ENG-SF22023-R1-CDs.pdf Markup Summary

[24 sheets total with utility plans]
PCD FILING NO.
PAGE 20-005 (FALCON MEADOWS AT BENT NEIGHBORHOOD REGULATORY PLAN)
PC-20-005 (FALCON MEADOWS AT BENT NEIGHBORHOOD REGULATORY PLAN)

Cursory comments

OVERALL SHEET

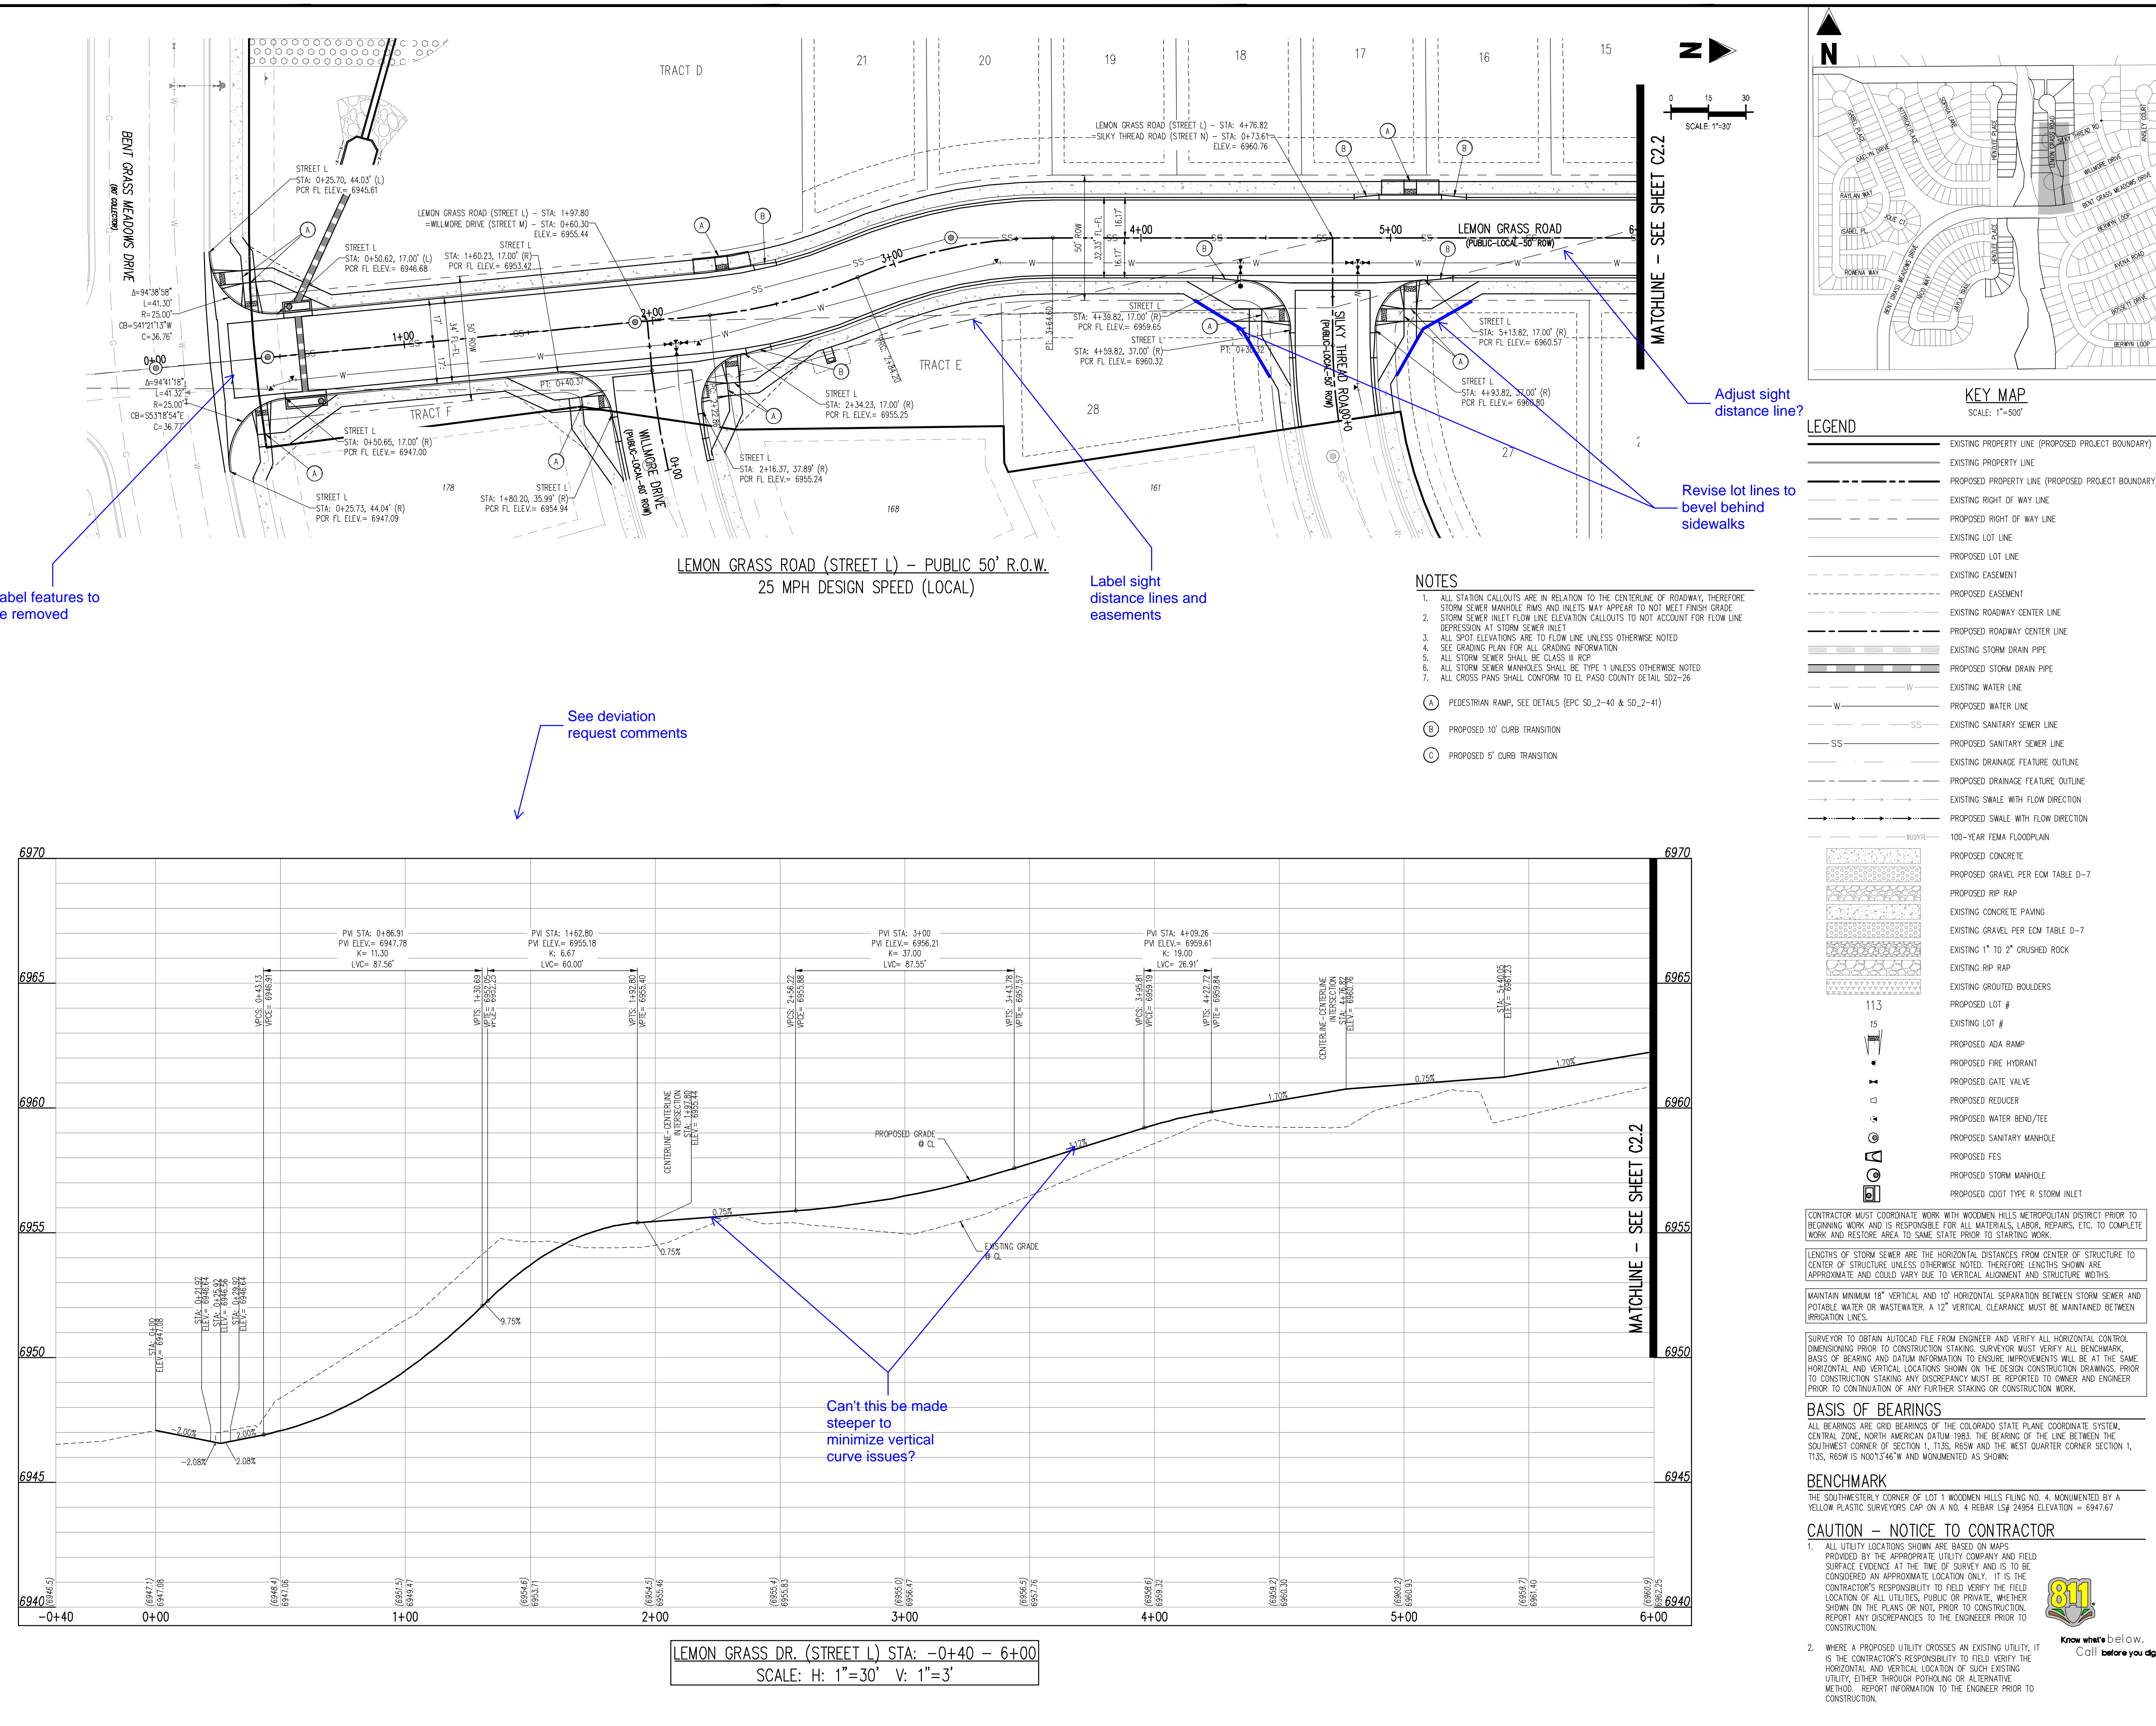
Adjust/add tracts per other comments

LEMON GRASS DR. (STREET L) STA: 6+00 - 7+94.08  
 SCALE: H: 1"=30' V: 1"=3'

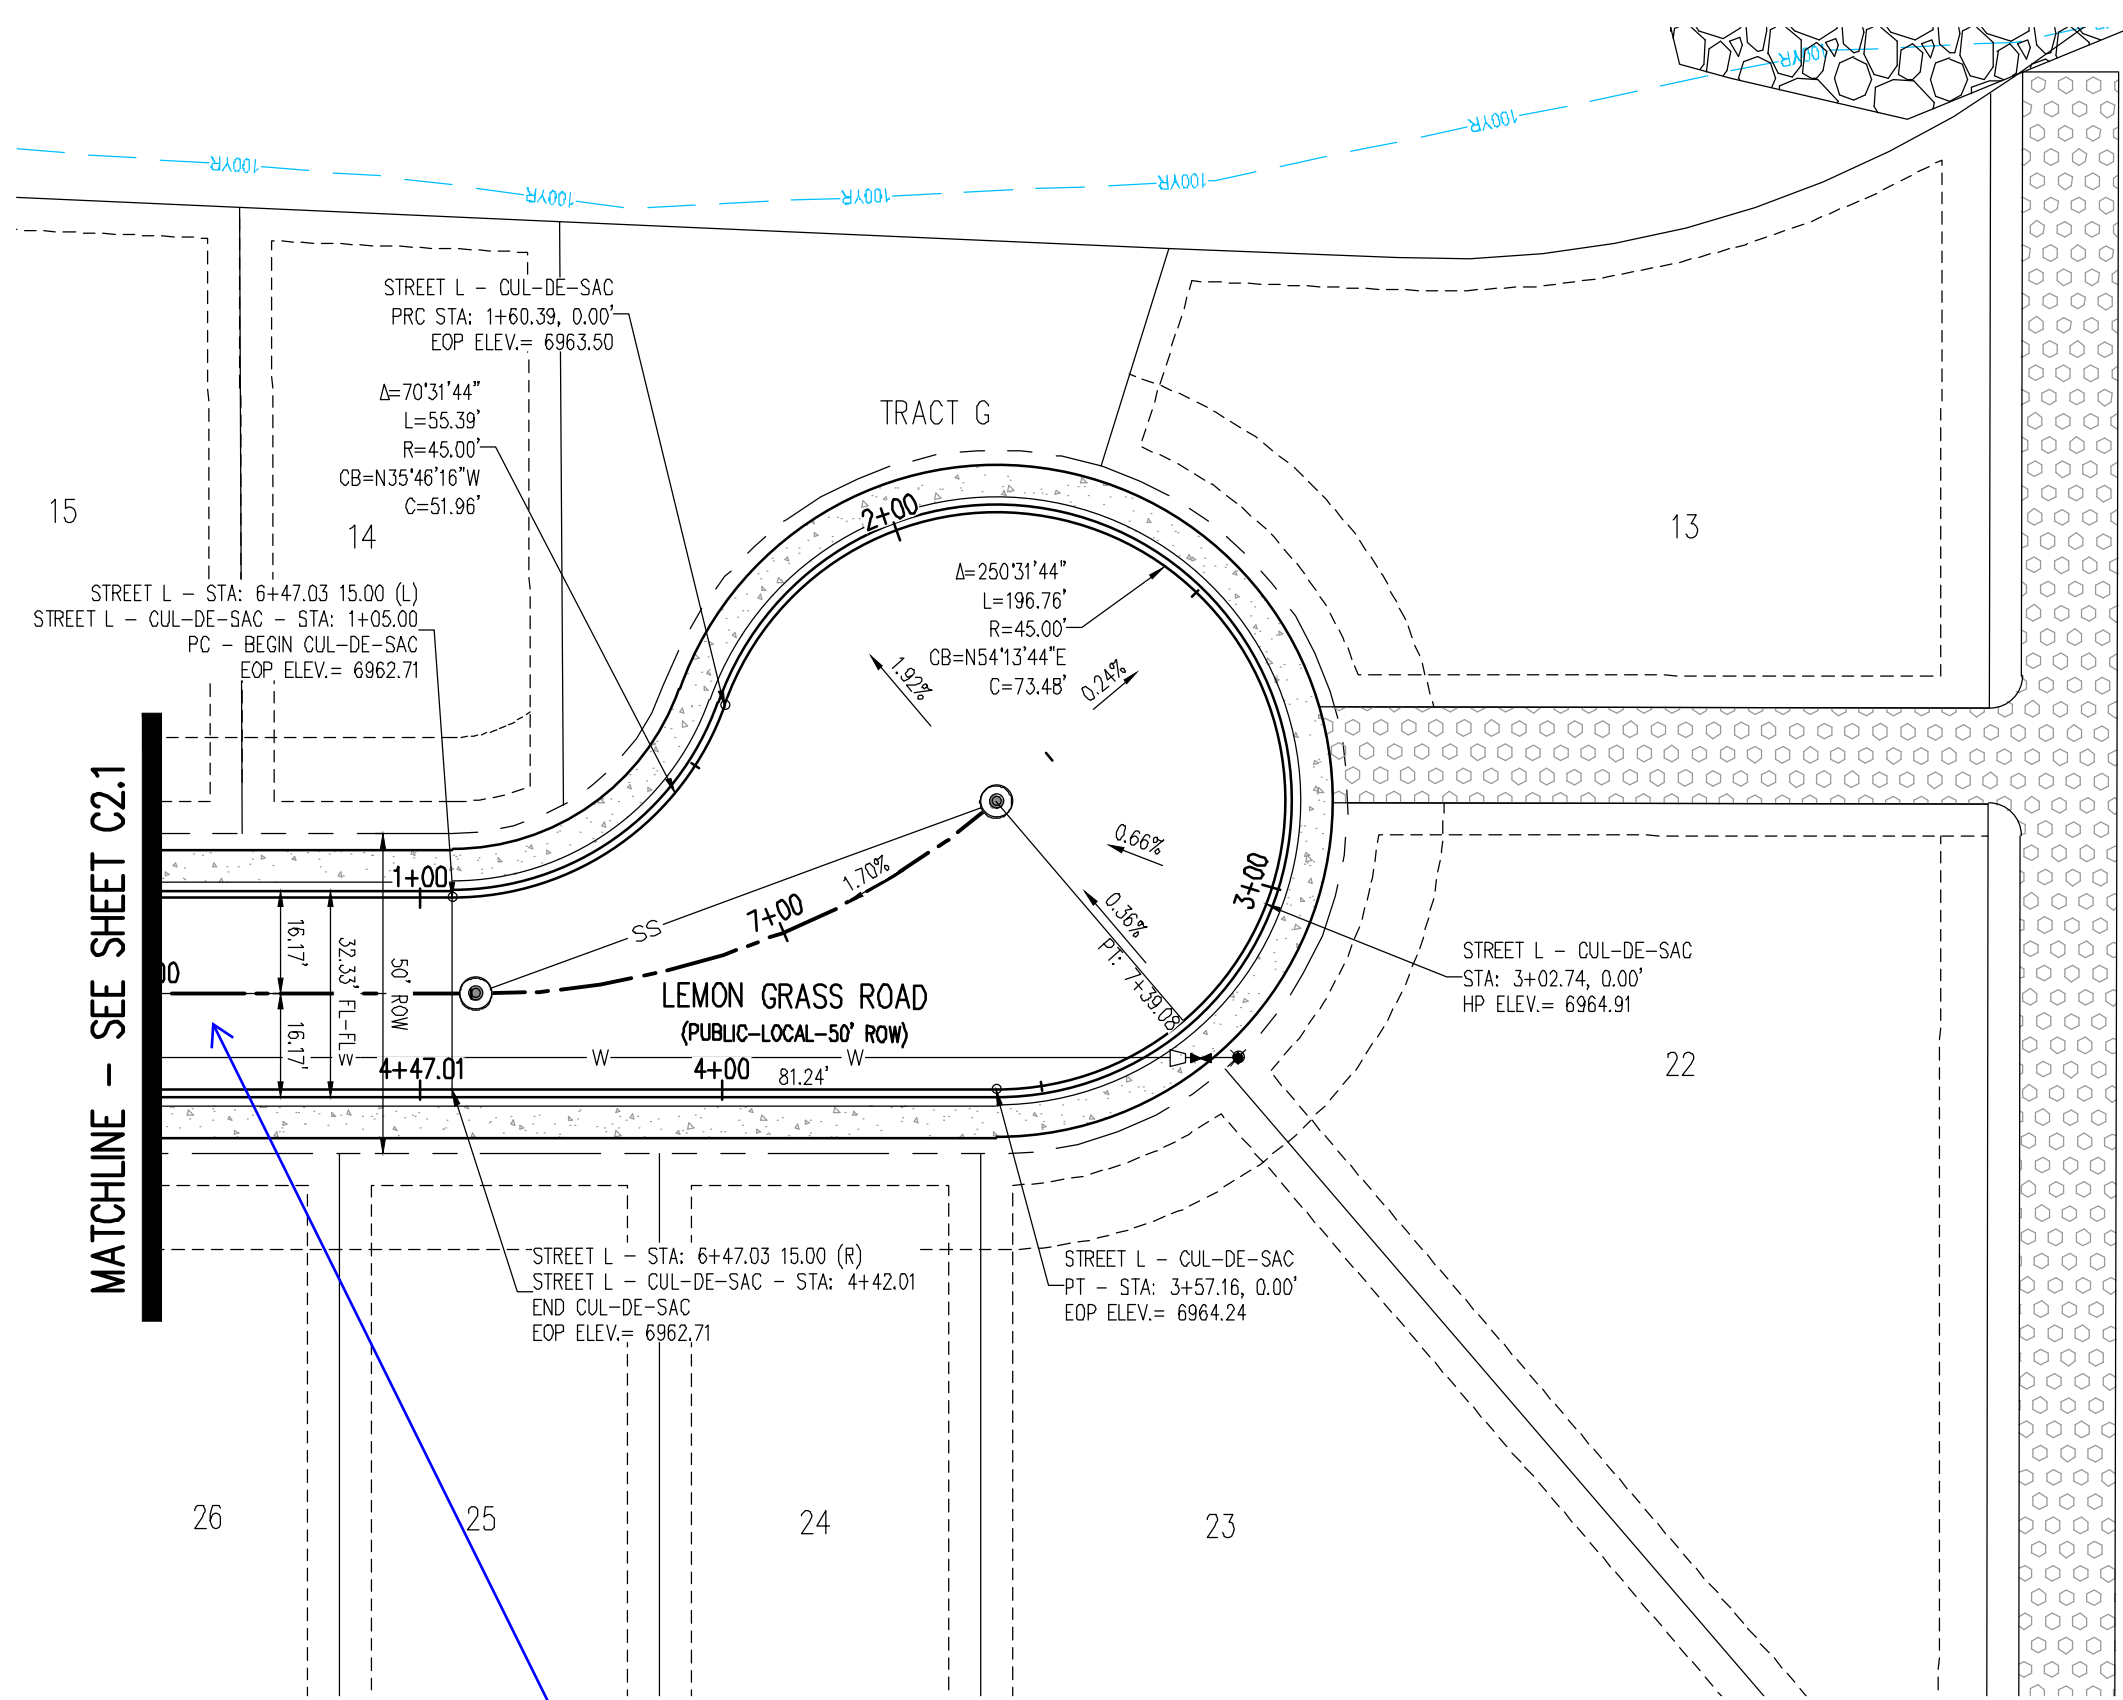
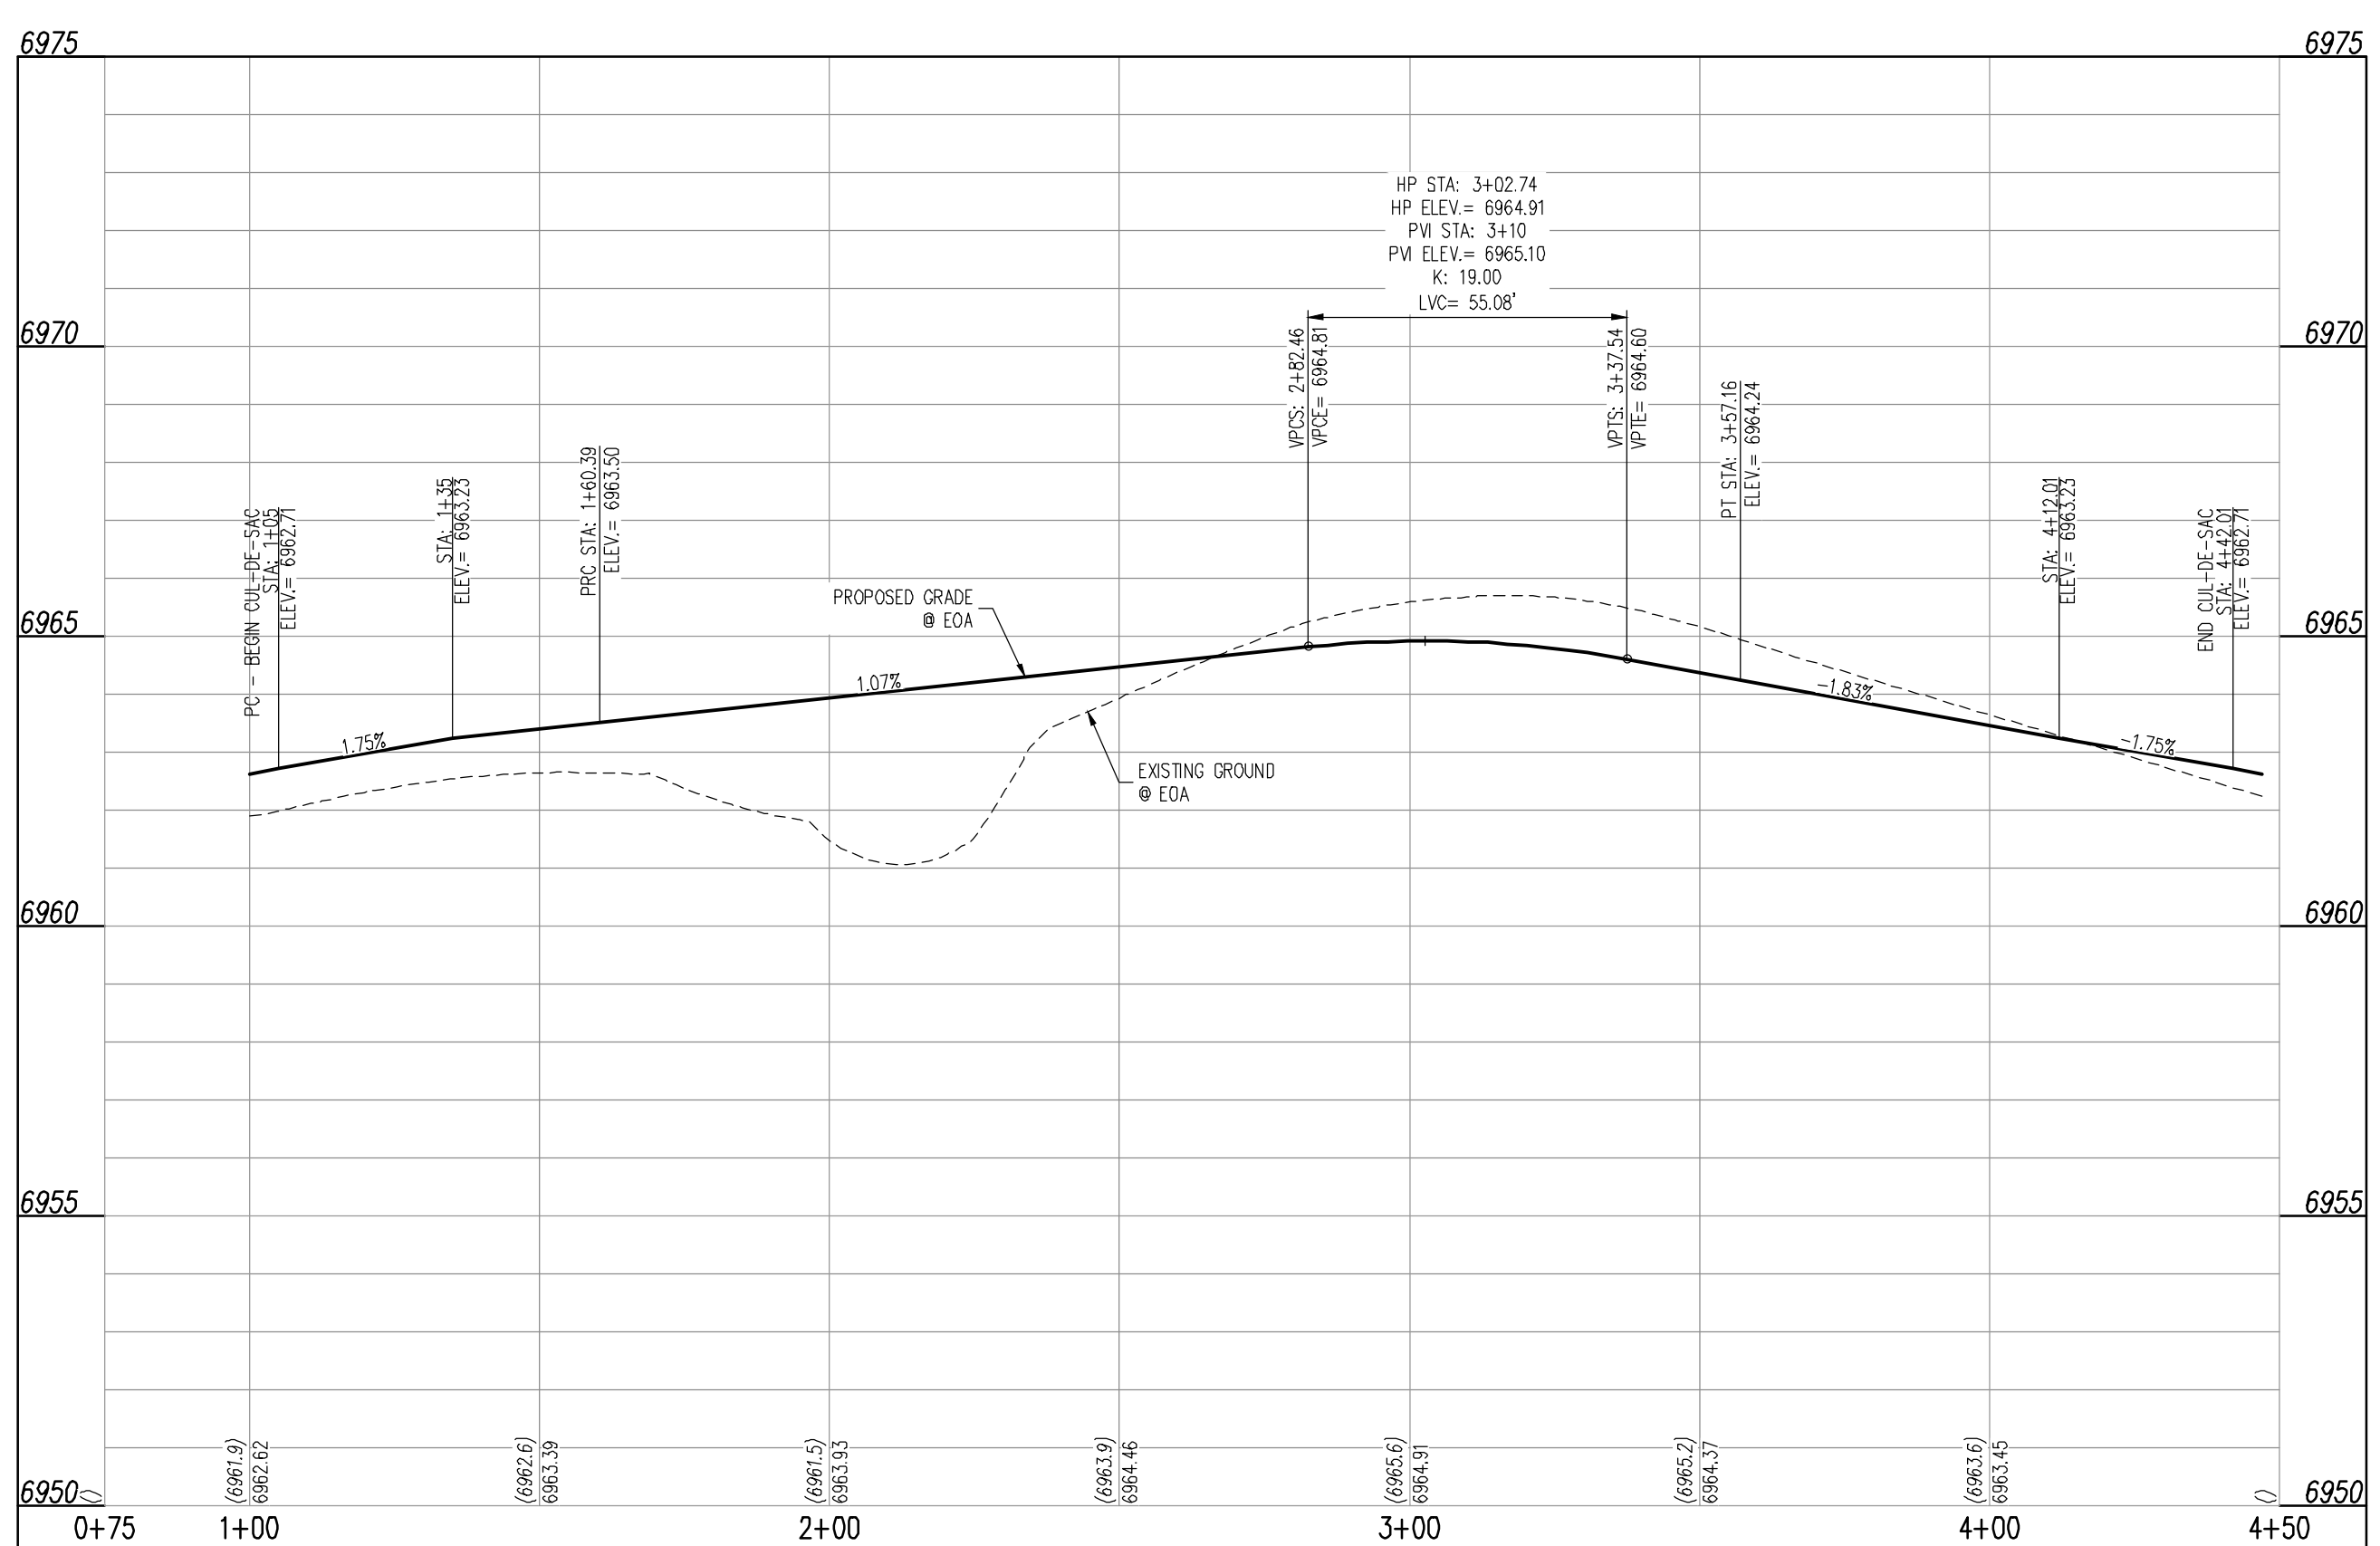
There appears to be a 3% grade break here - revise tangent to VC

Reduce grade break to <1% and space away from the vertical curve or remove and adjust the vertical curve

Provide vertical curves or reduce the grade break to $<1\%$

Does not meet minimum K values

Provide sight visibility triangles

Label as centerline-centerline intersections
